Date: 3rd October 2022

Our Ref: 22/5297

**RE: DART+ West Project and Peter Joseph and Eimer Fallon
Lands in the townland of Ballycurraghan Maynooth Co Kildare**

On their behalf we wish to lodge an observation and objection to the granting of planning permission for the DART+ West Railway application. We enclose herewith the statutory fee of €50.00.

Drawn By: LA	Checked By: MH	Approved By: MH
Scale: 1:1250 (@A0)	Date: May 2022	
Area No: 039	Plan No: WORKS LAYOUT PLAN NO. WP039

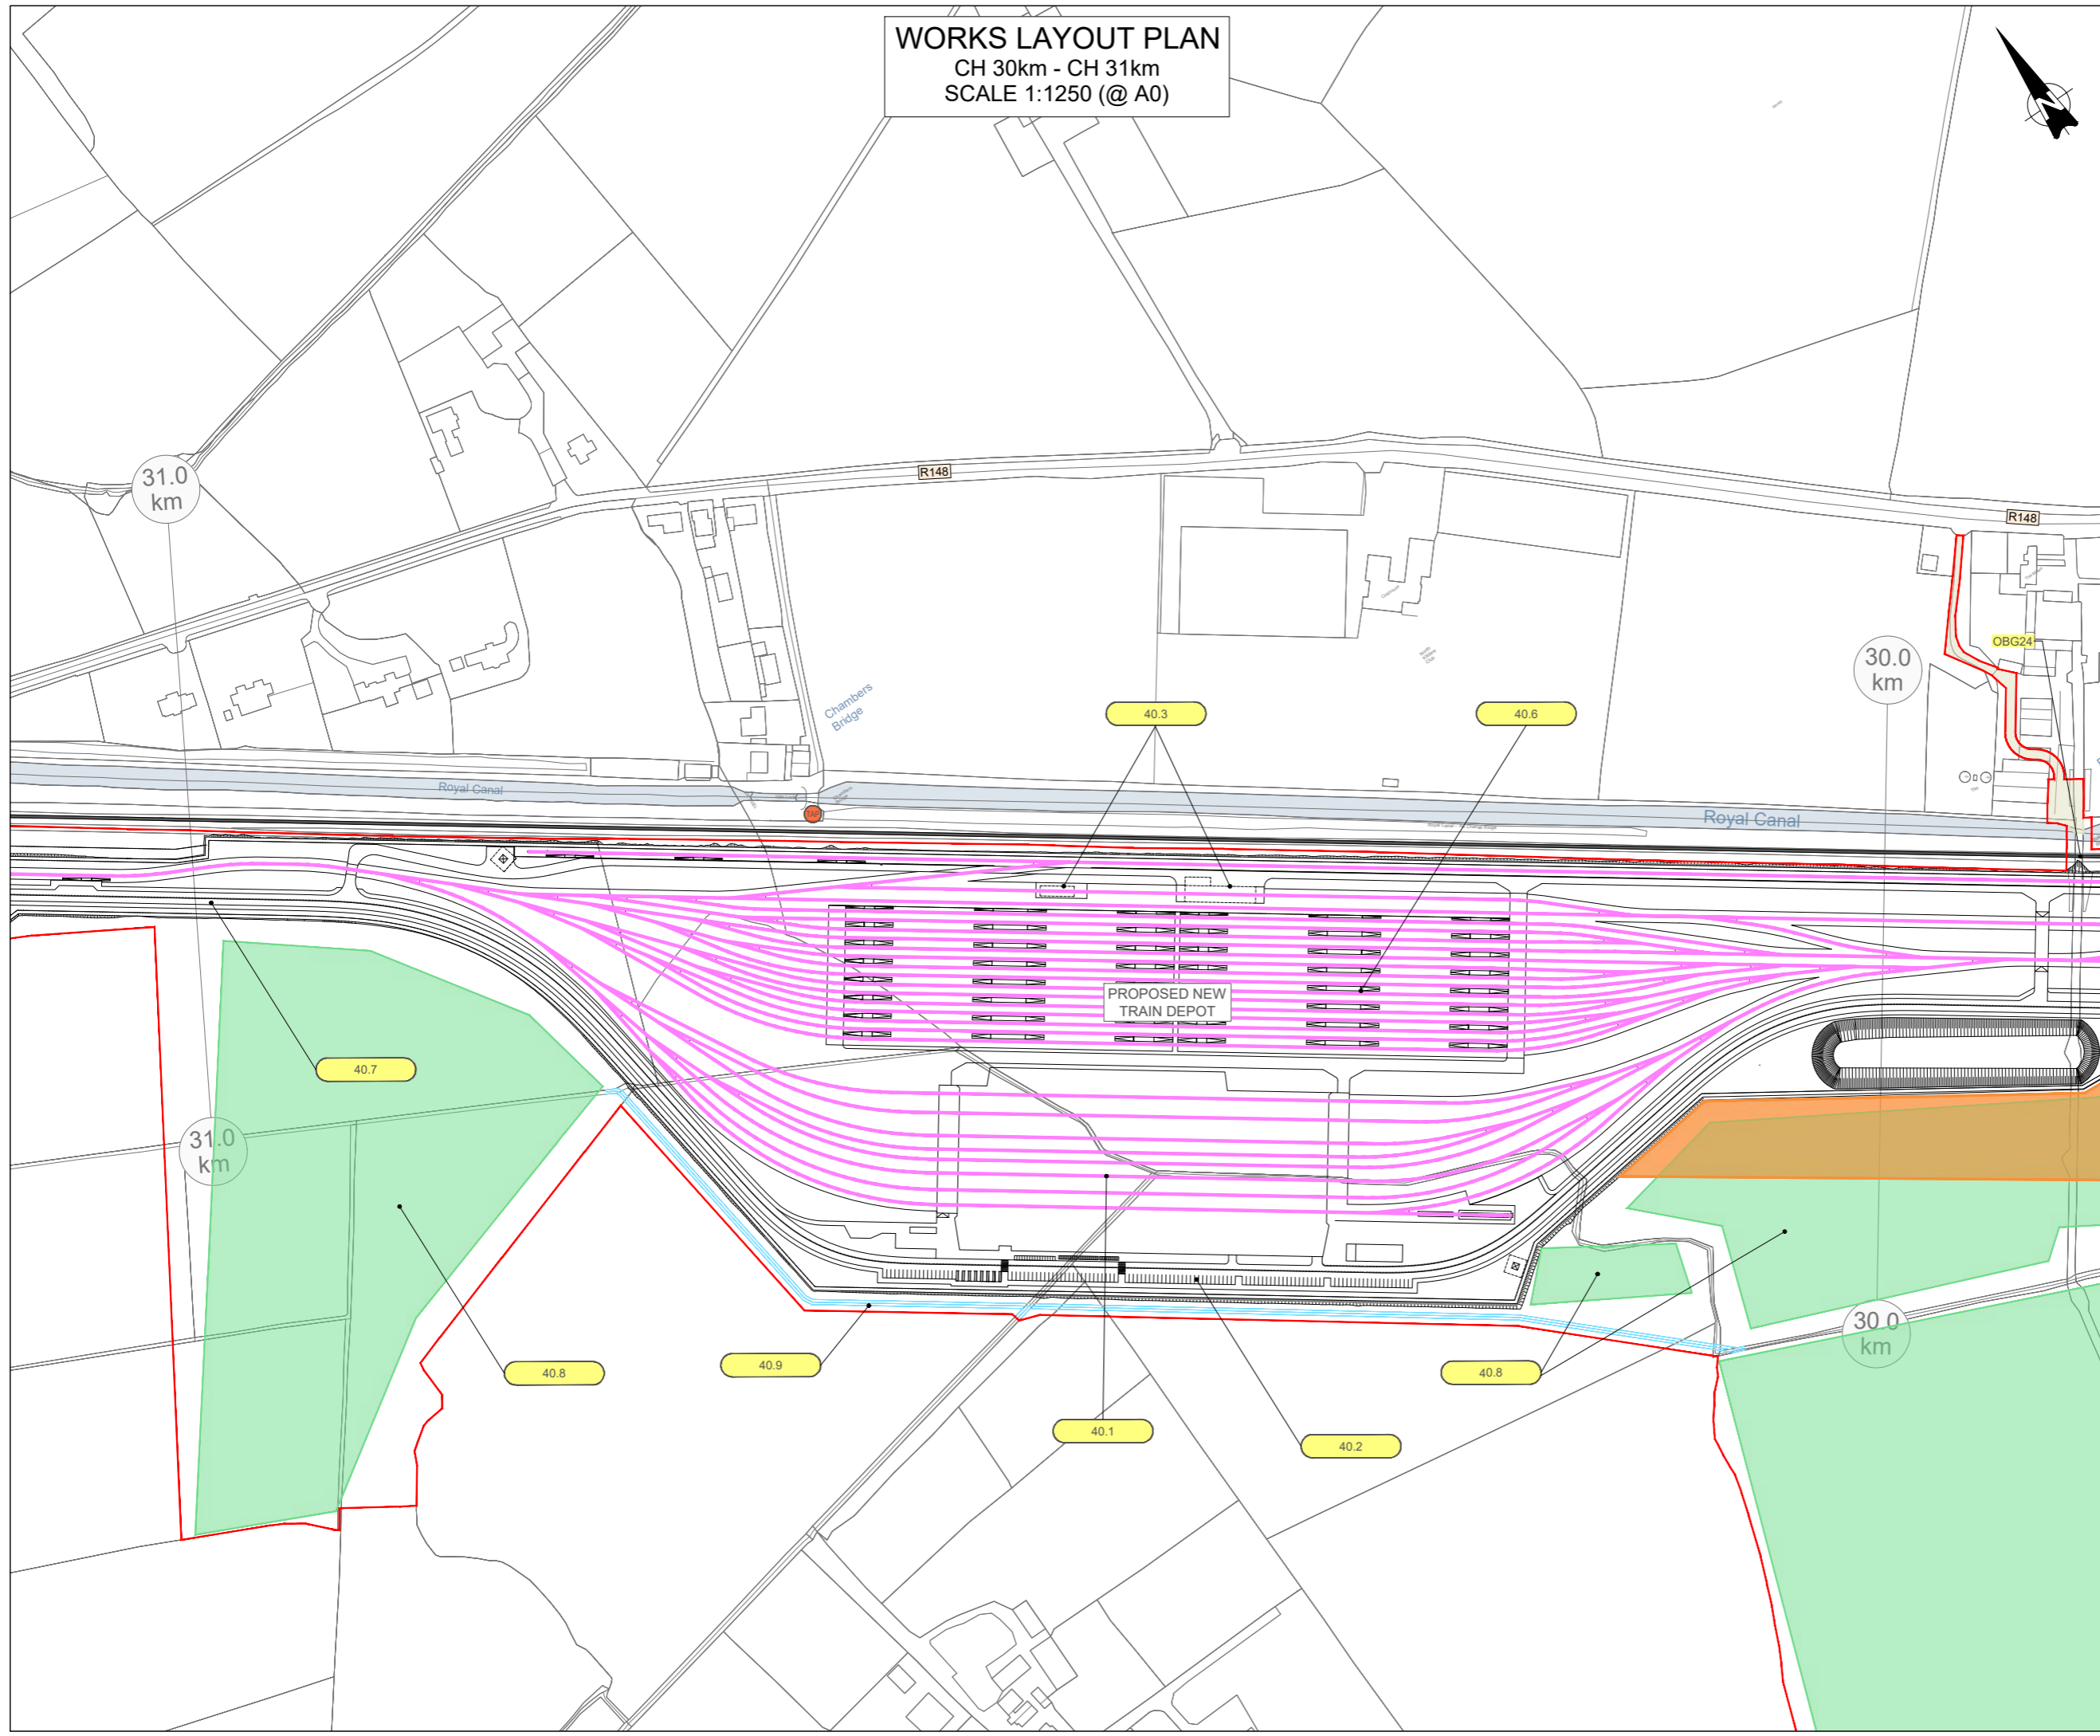
There is the construction of the new bridge and road access of the R.148 existing road. The road access to the 'Depot' is located adjacent to the North East corner of Fallons Paddock as shown on drawing 'Works Layout Plan No WP39'.

The entrance roadway to the marshalling yard and the yard tracks are opposite the paddock. There will be considerable excavation works and the importation of ballast, tracks and overhead structures. The extract from the Book of References outlines a very large and industrialised construction which will create serious noise and disruption to the Equine Centre.

The 'Depot' is an offset from the tracks of the main line. The choice of the location of the 'Depot' adjacent to the equine centre is unfortunate. The operation facility of the 'Depot' is directly opposite the Fallons Paddock Ref 39.8.

The permanent compound and storage material for the 'Depot' is also closely opposite the Fallons Paddock Ref 39.14 and 39.15.

The trains entering the 'Depot' will travel in an East to West/West to East direction entering and leaving the 'Depot'. Thus there will be over head operational lighting particularly at the control centre Ref 39.8 and 39.9.

The trains stopping and starting will give rise to flashes. This operation is directly opposite the North West corner of the Fallons Paddock.

The location of the largest of four compounds directly opposite the Fallons Paddock will create the most intense pollution. The hauling in of the ballast for the marshalling yard and the spreading and compacting of hardcore for road works, tracks and buildings will cause serious air pollution. Construction works will also cause dust.

The wastewater from the construction site will have to be treated and it is not clear from the drawings how this will be achieved.

The operation of the 'Depot' with trains coming and going on a constant basis in a confined site will give rise to air borne dust from ballast and the general environment of the 'Depot'. The size of the attenuation tank appears to be small and there does not seem to be sufficient volume provided for the run off of the industrial use of the 'Depot' compared to the existing normal run off of agricultural lands ie the capacity of the attenuation tank is too small.

The Fallons are asking the Bord to request Irish Rail to find an alternative location for the 'Depot'. If this cannot be achieved they will have no alternative but to seek compensation for the injurious effect caused to their lands and their business. They will suffer it's impending closure as a result of the future operation of the DART+ West System.
